RE: Emirates One&Only MP06_0310-Mod 4 - Temporary Changes to Helicopter Transport

Objection to the proposal and request that it be refused

Figure 3. Preferred flight paths.

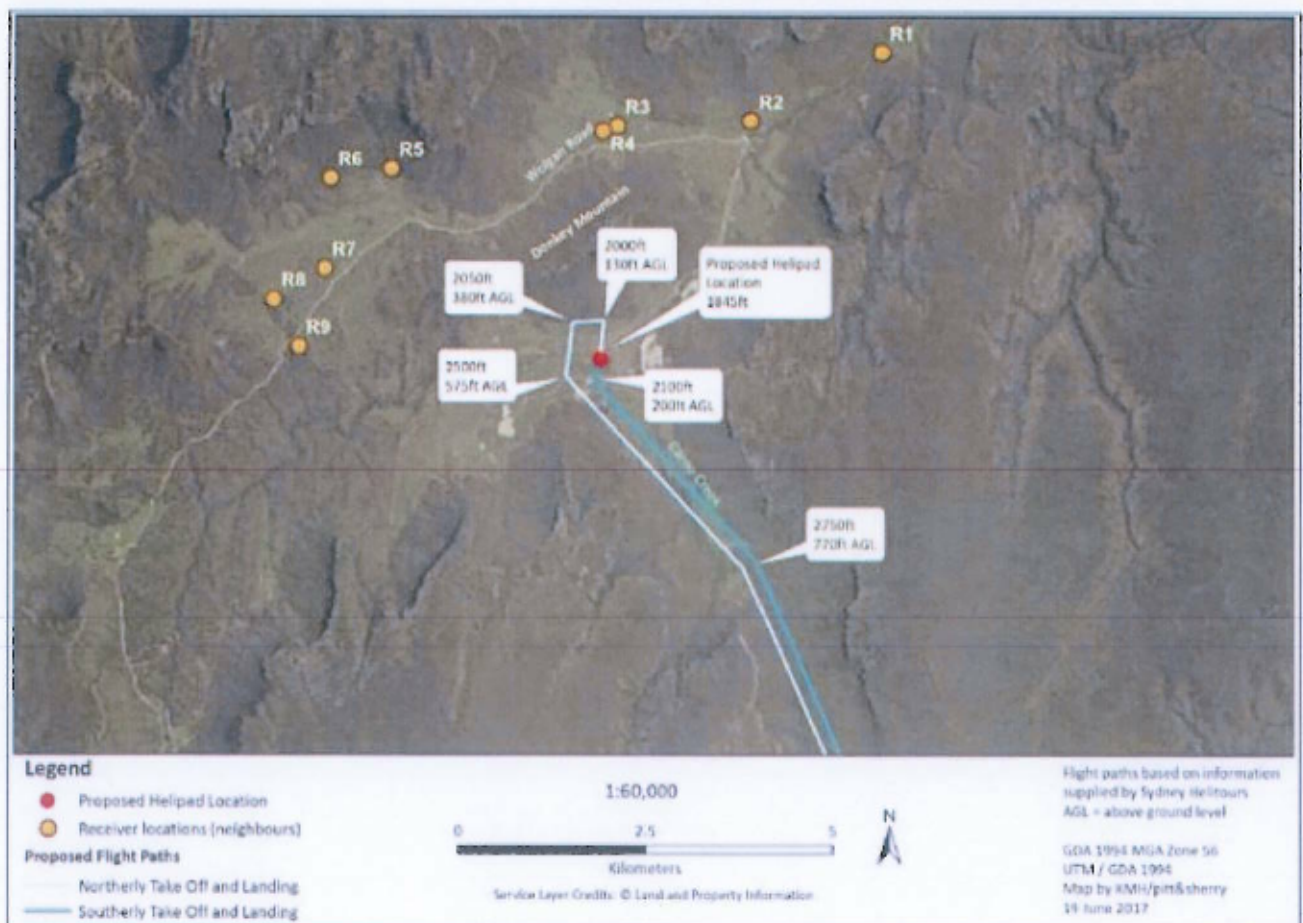
I object to the proposal by Emirates Hotels (Australia) Pty Ltd to increase helicopter flights to the Wolgan Valley Resort from 14 return flights per week to 105 return flights per week (or a maximum of 15 return flights per day), reducing to 50 per week (or a maximum of 10 per day) once practical 2WD access is restored to Wolgan Valley, as well as to the proposed change to the flight path.

The proposed flight path would directly intersect with established flight corridors and habitats.

Given that a new flight path is proposed, it is unacceptable that no comprehensive assessment of ecological impacts has been undertaken.
